REVISION TO:
MASTER DEVELOPMENT
DRAINAGE PLAN
MERIDIAN RANCH
EL PASO COUNTY, COLORADO

March 2021

PCD Project No. SKP-XXX

HISTORIC CONDITION - SCS MAP

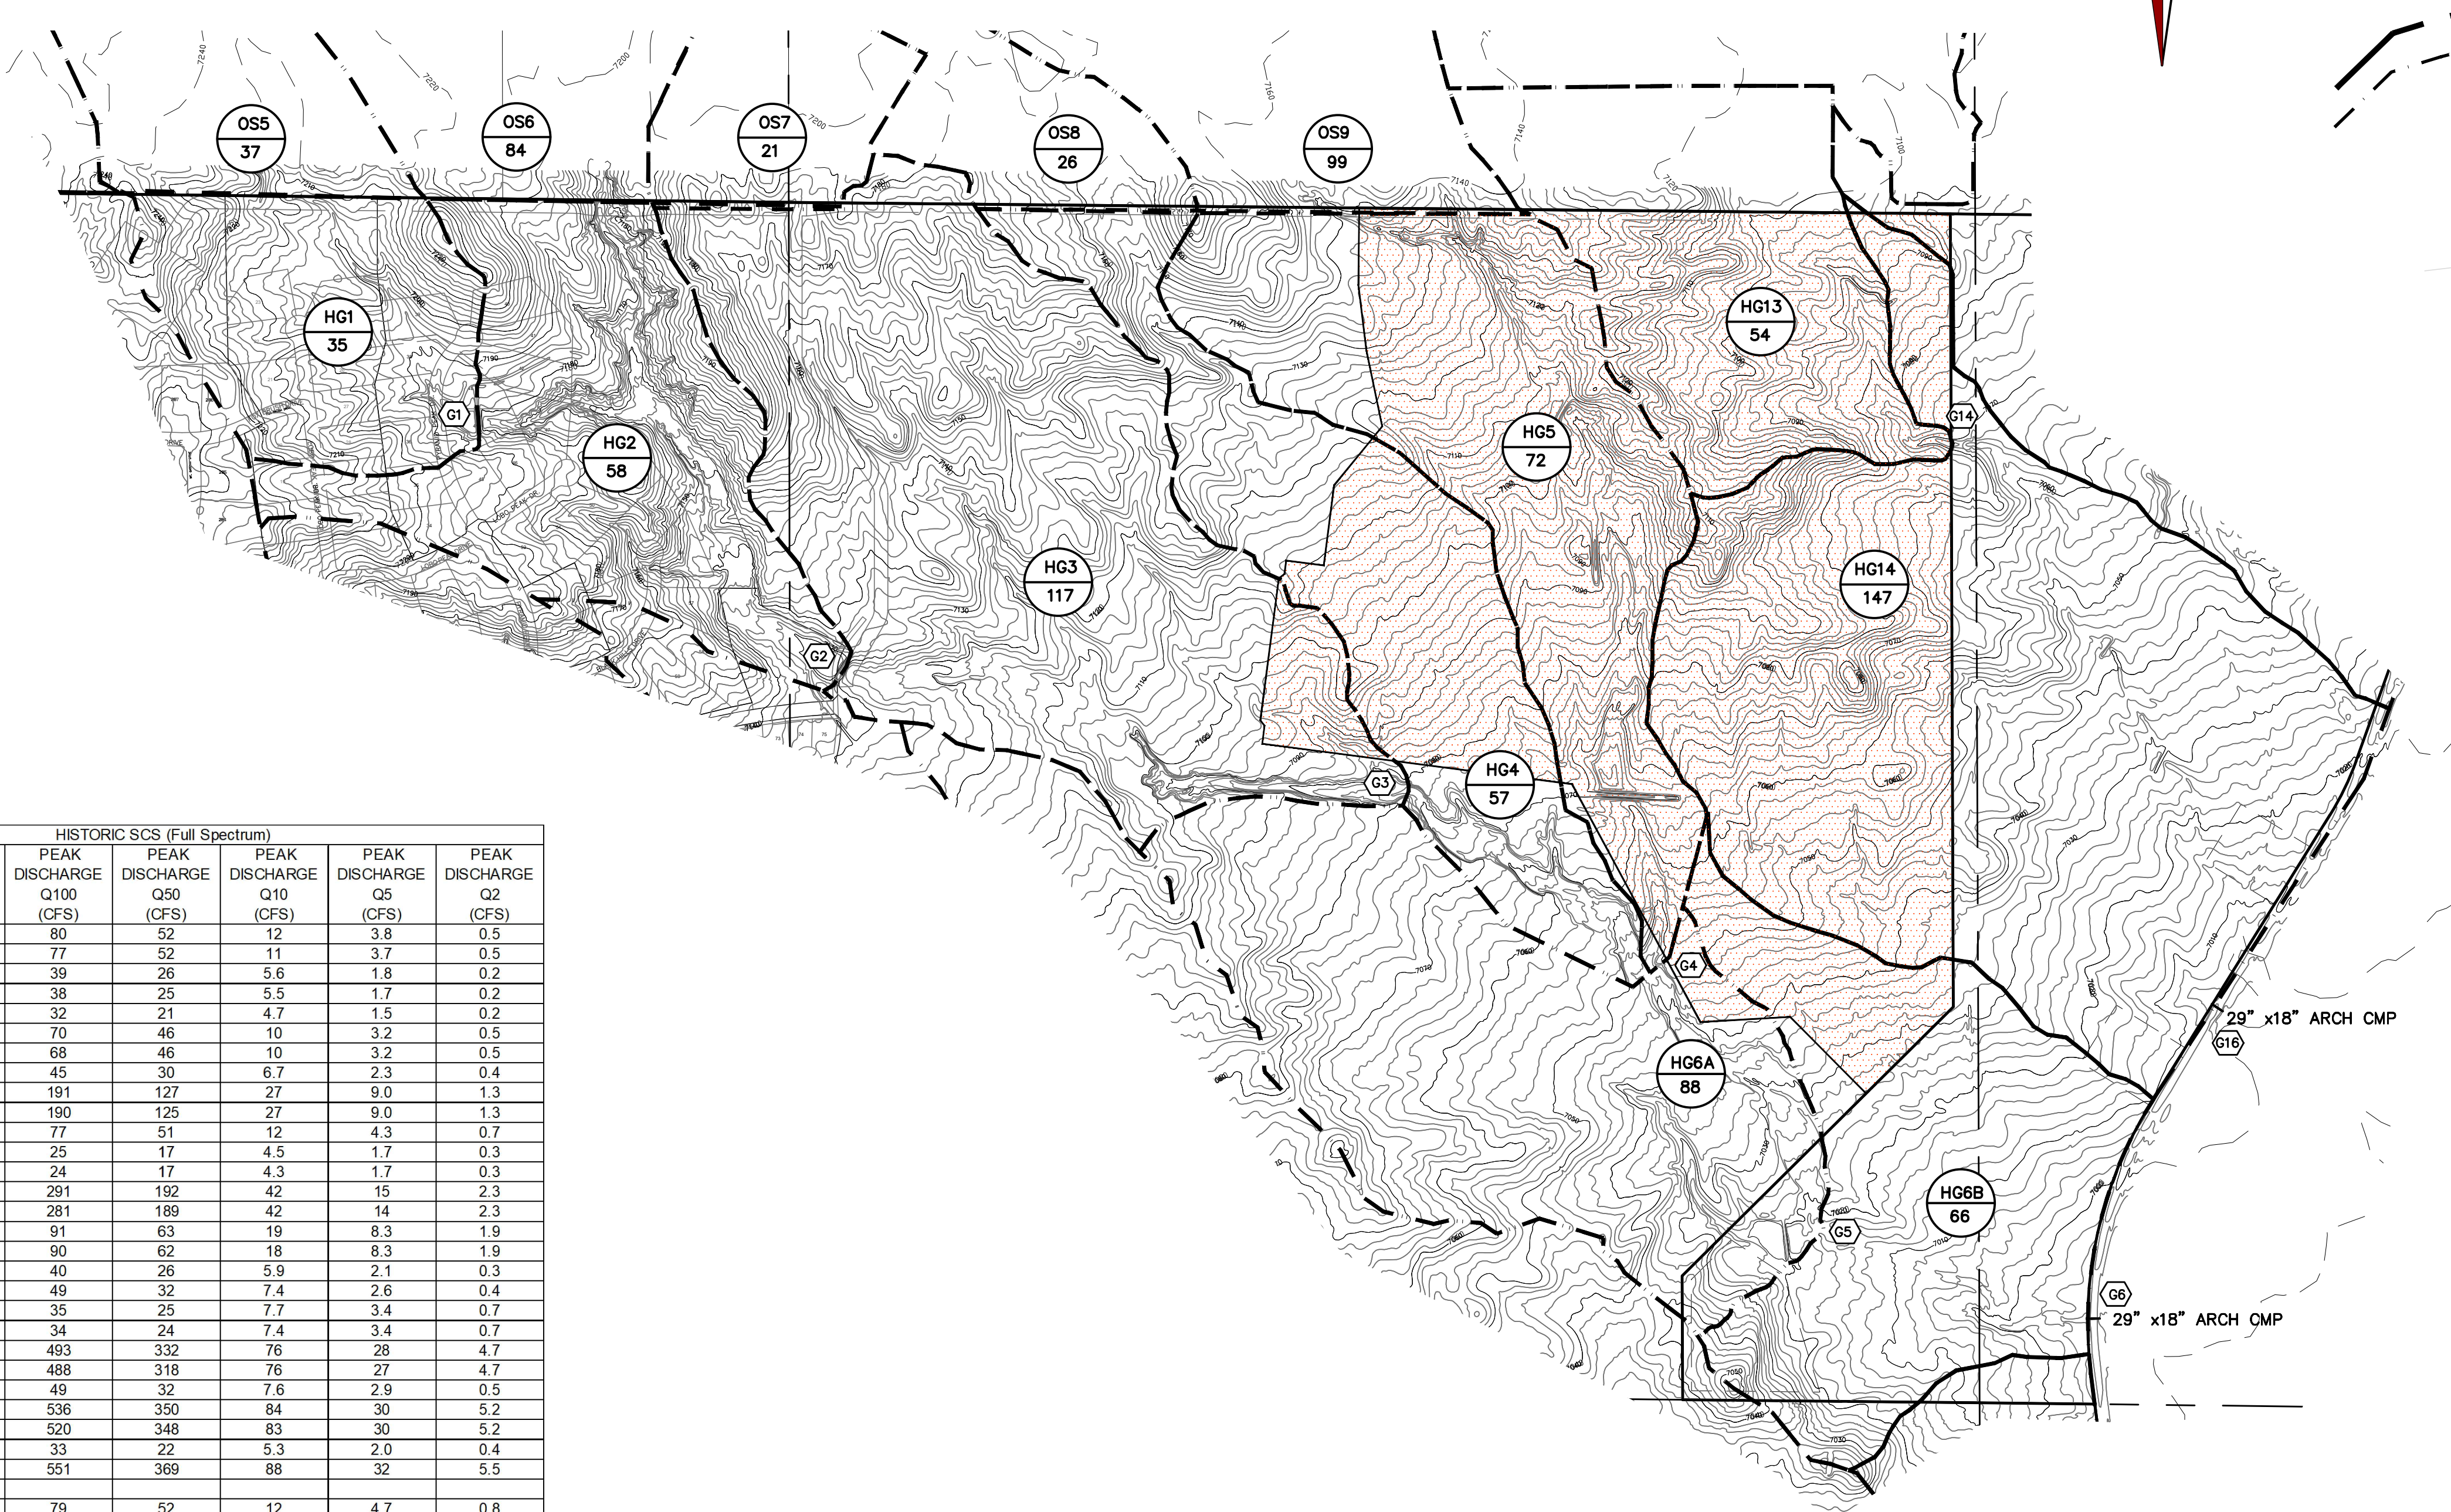
Explain why the Historic SCS peak discharge for G4, G5, G6 changed (decreased) from the previously approved MDDP.

During the research to discover the reason the 2017 MDDP Historic flow rates were higher than the 2021 MDDP Historic flow rates.

- The Control Specification for the run had a 2 minute interval as opposed to the current 6 minute interval.
- This change in interval periods resulted in lower Historic flow rates and higher Future rates for all design storms.

The interval will remain at 6 minutes as this appears to be more conservative. Lower target historic rates to be matched with higher developed flow rates. I believe this will result in storm drain facilities being designed to convey larger flow rates and the detention ponds designed to hold a larger volume.

No change to the report.
